**WELWYN HATFIELD BOROUGH COUNCIL  
DIRECTORATE OF STRATEGY AND DEVELOPMENT**

**DELEGATED APPLICATION**

**Application No:** 6/2016/2514/EM  
**Location:** 7 Densley Close Welwyn Garden City AL8 7JX  
**Proposal:** Enclosure of existing covered area to rear of property with installation of bi-folding doors  
**Officer:** Mr A Mangham

Drawing No: 4025-P01 Revision: A

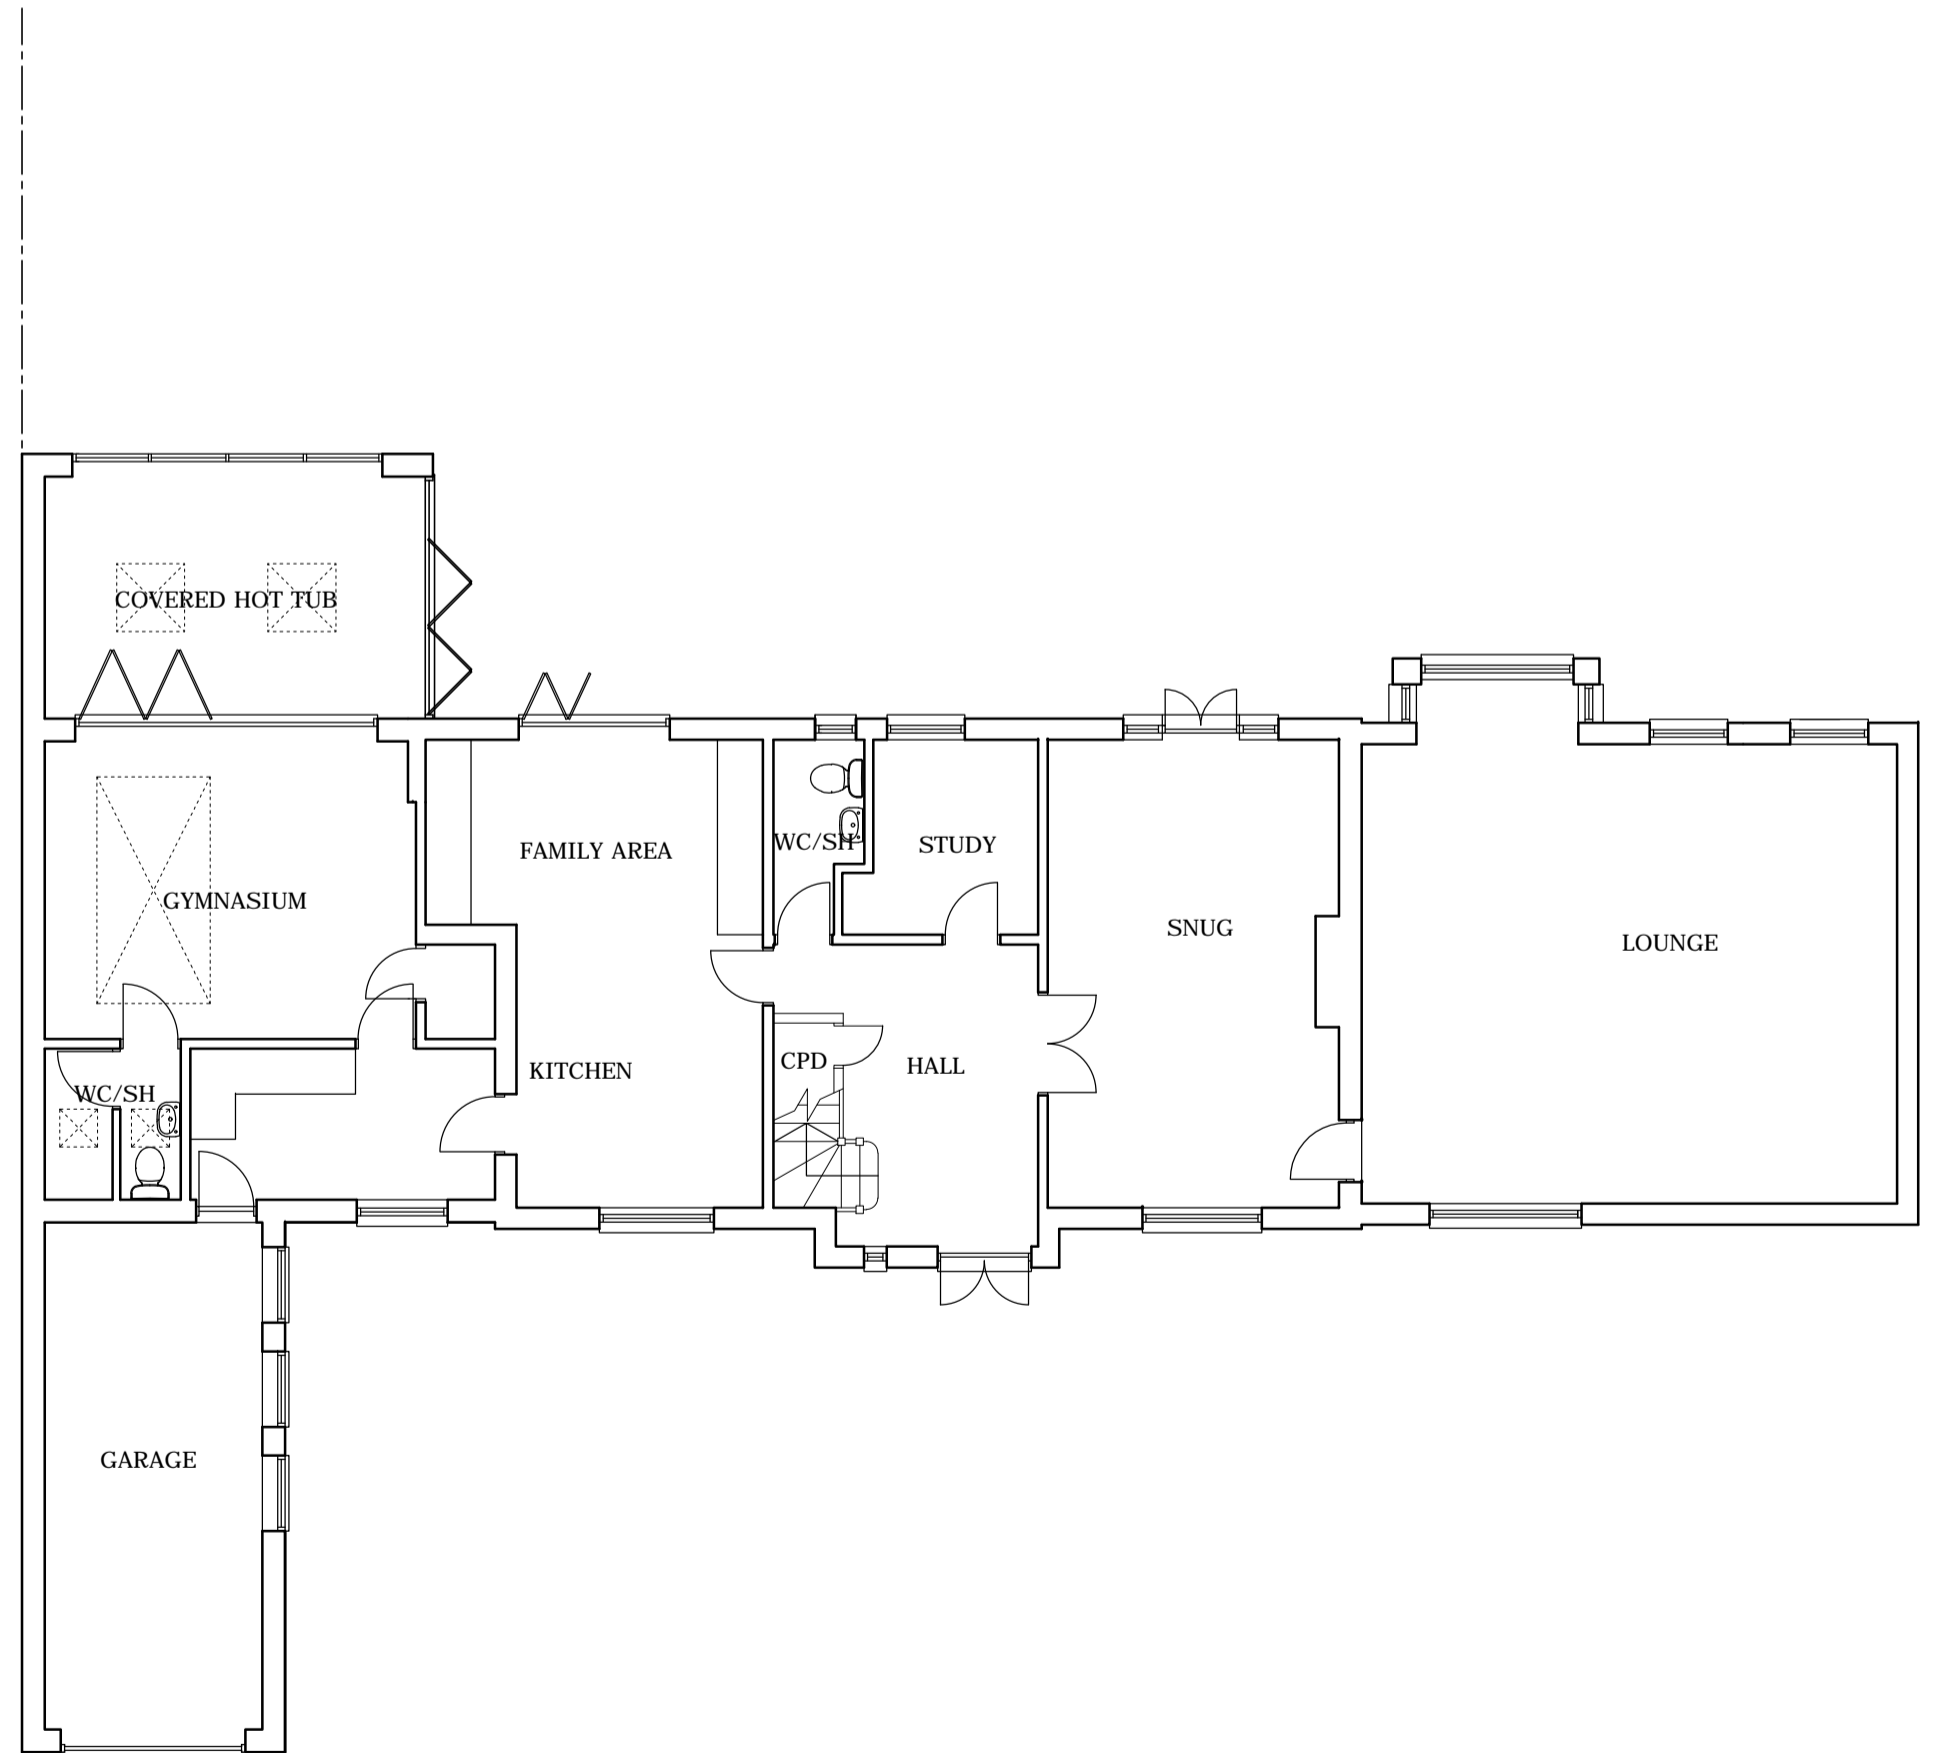
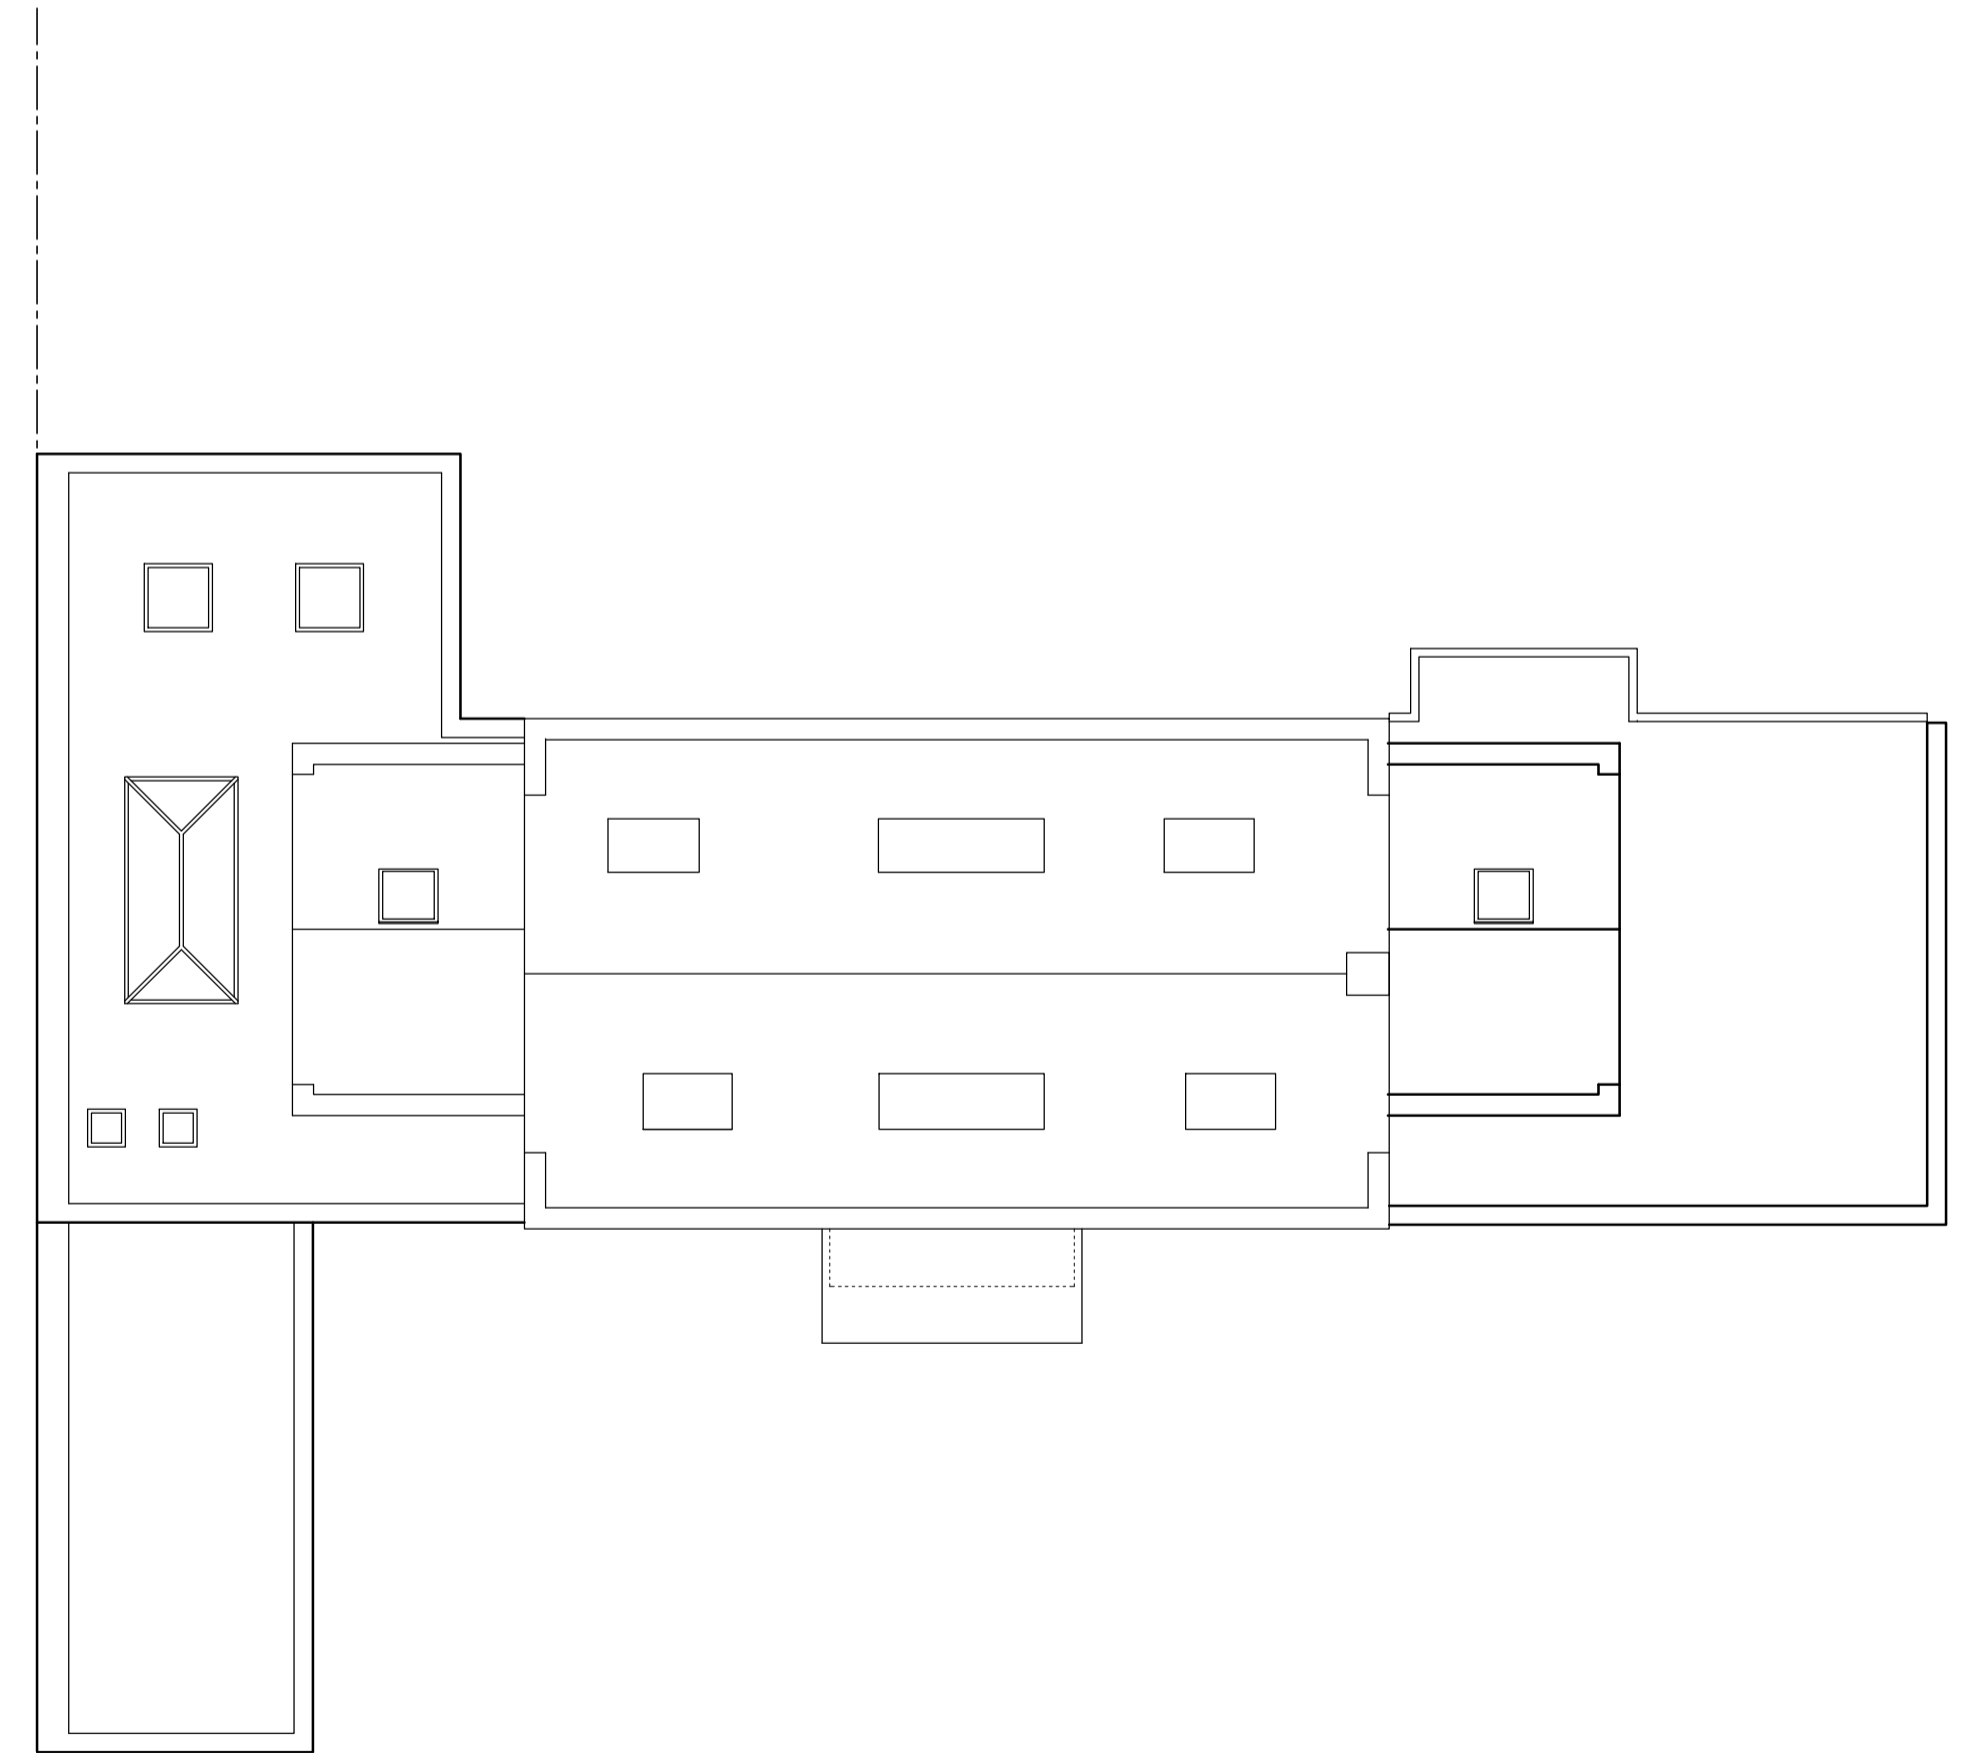
The bi-folding doors, in particular having regard to their rear location, would not create a prominent feature that would detract from the character of the street scene or area. The introduction of these doors and infilling of this area considered to be subordinate to the existing dwelling, and as extended, and is considered to be acceptable in this regard.

No. 19 Scholars Mews, a detached property, is located south of the host properties rear garden. The proposed bi-folding doors, and whilst facing the objector's rear two storey elevation, will result in a spacing distance of approximately 30 metres.

This spacing distance, whilst there will be a resultant visual relationship, is considered not to result in any significant degree of overlooking between the subject doors, including its use within, and the rear elevation of the objectors property that would be considered detrimental to the extent to warrant a refusal on the detrimental impact on living conditions. In these circumstances, it is also considered that a condition to impose obscure glazing, or indeed non-opening windows, is also unjustified by virtue of the quoted extensive spacing relationship.
